Markup Summary

2 NORTH ELEVATION
SCALE: 1/8"=1'-0"

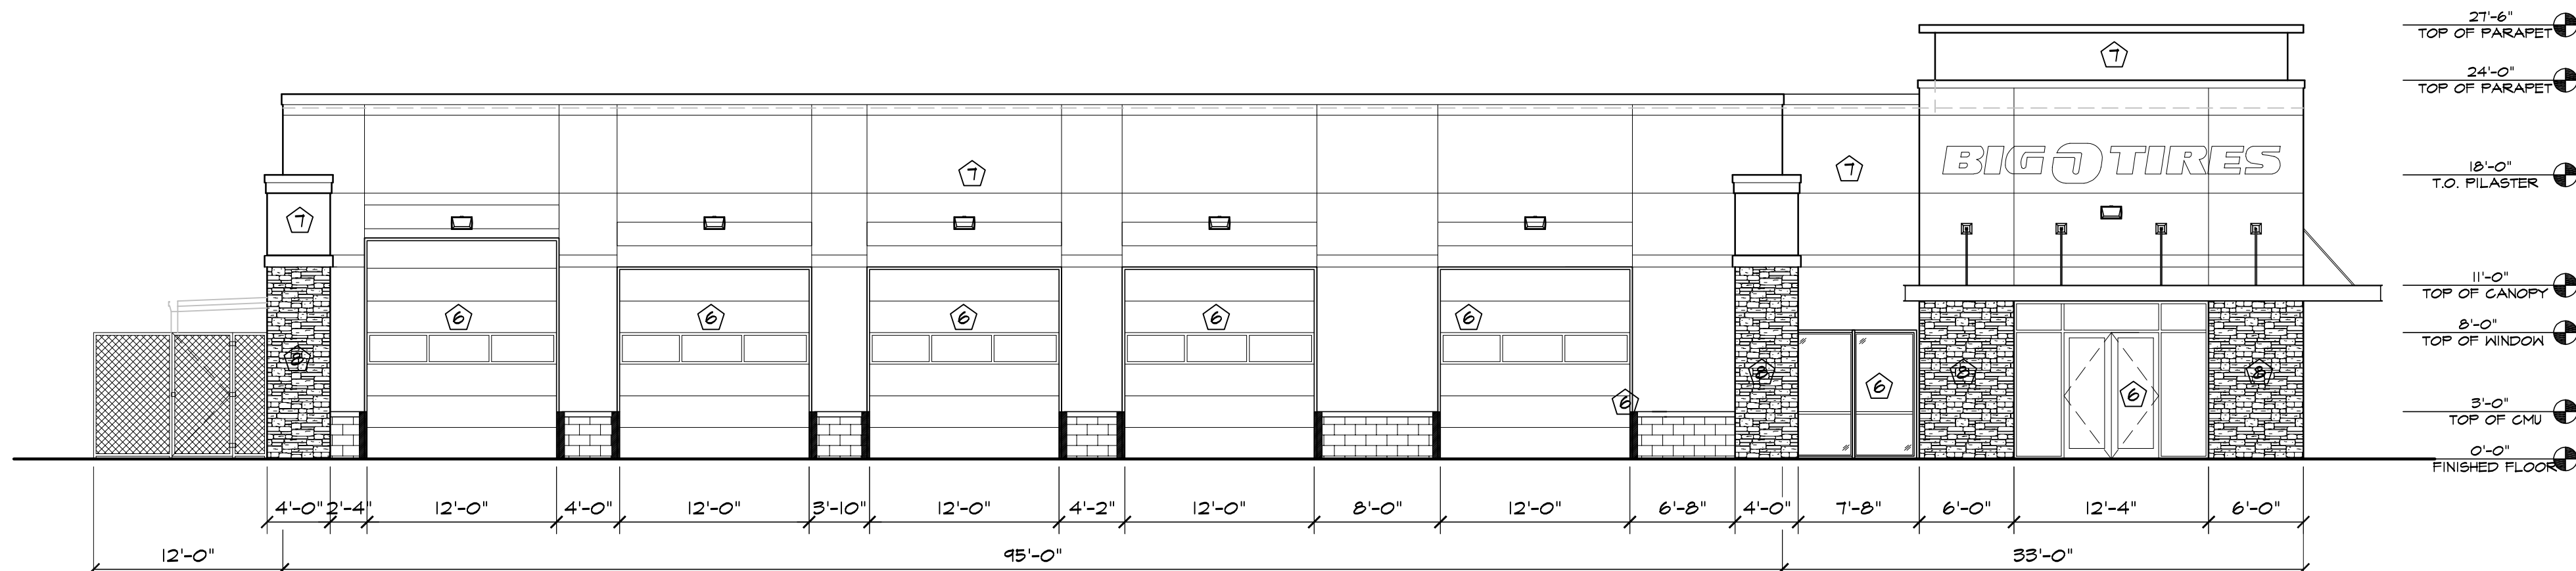
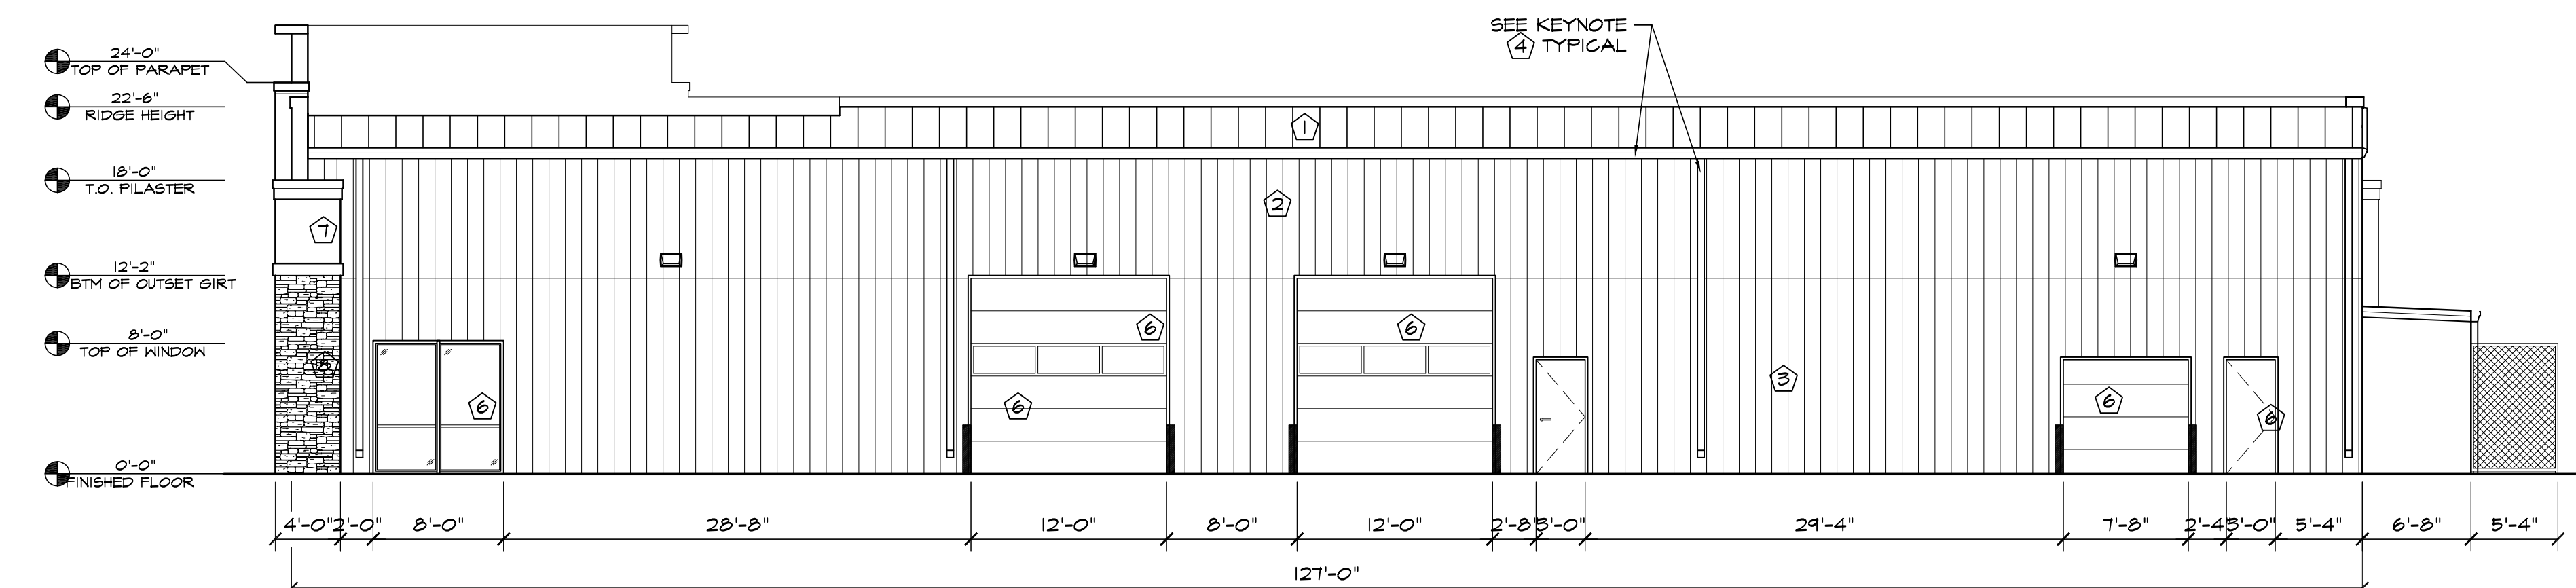
State that these are not bays, but just garage doors.
